MECKLENBURG COUNTY  
Park and Recreation Department

MEMORANDUM

**DATE:** March 23, 2023

**RE:** Rezoning Petition #2022-175  
PID# 10505103

SHEET NUMBER  
RZ-01

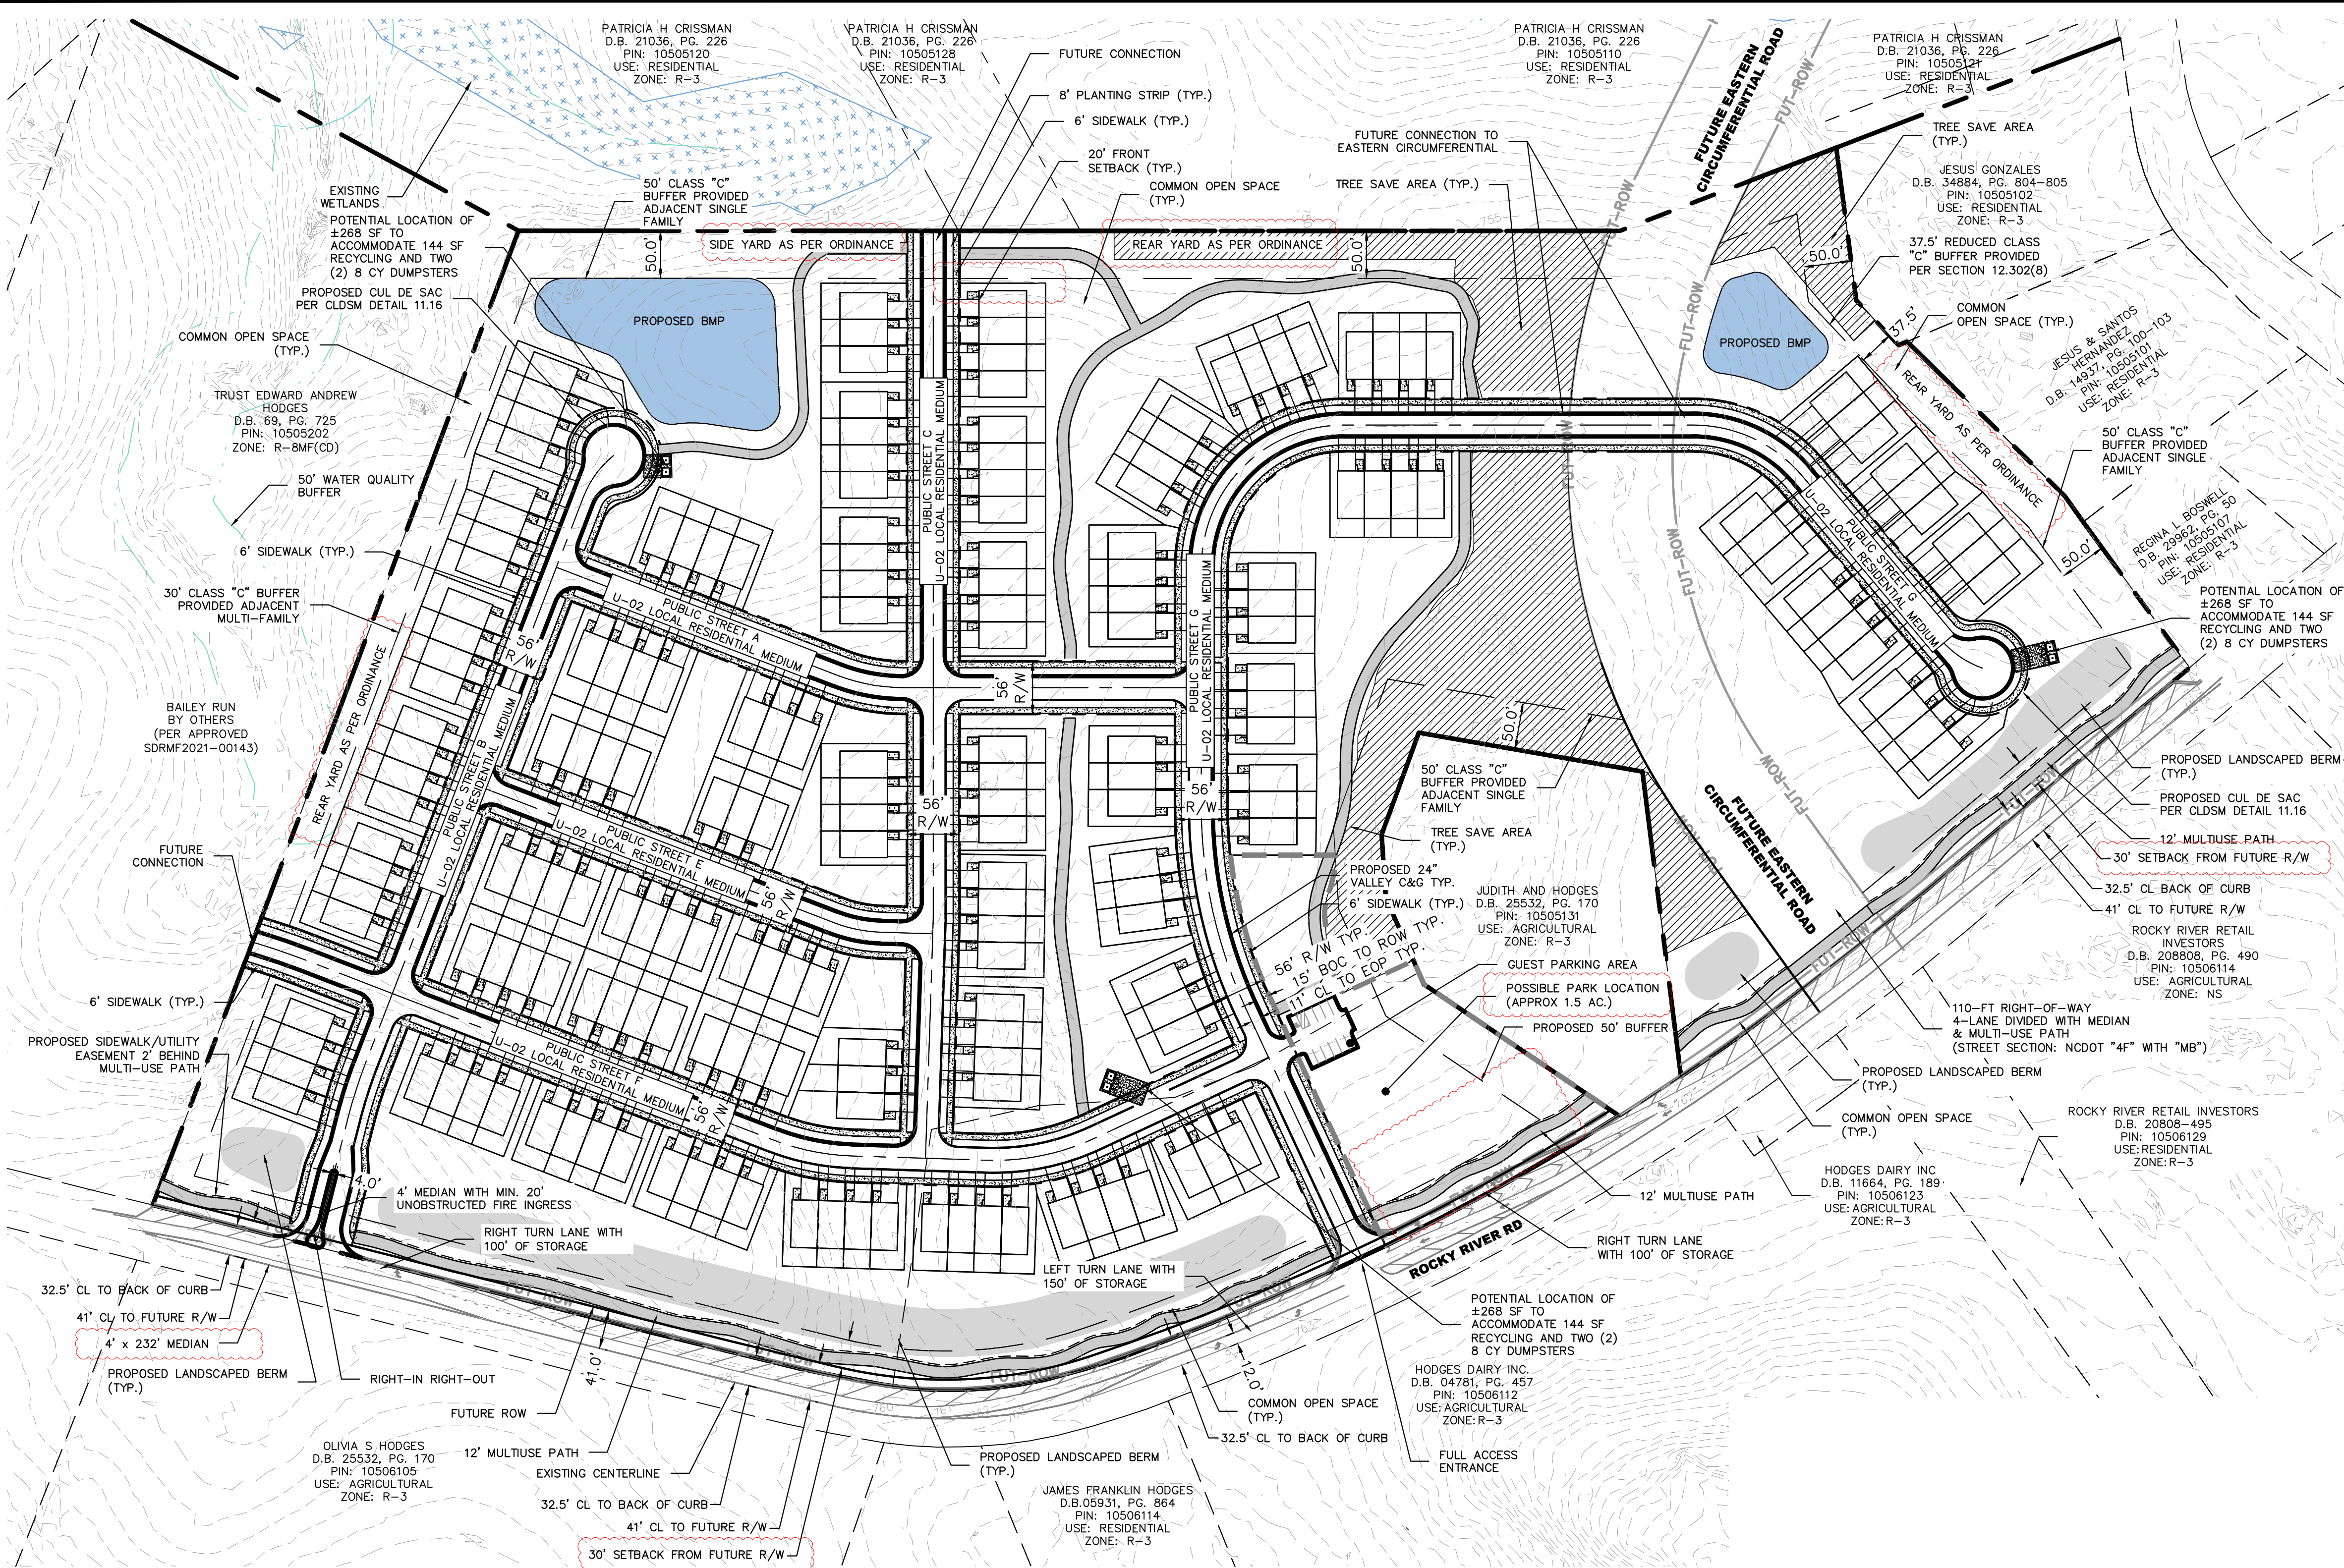
We did not see this request noted on the revised site plan - MCPR requests a minimum of **1.9** acres to be dedicated and conveyed to Mecklenburg County for a future neighborhood park. This requested park land shall be adjacent to a public right-of-way for access and is conducive for the development of the typical amenities found in a neighborhood park and cannot include tree save parcels or stormwater BMP's.
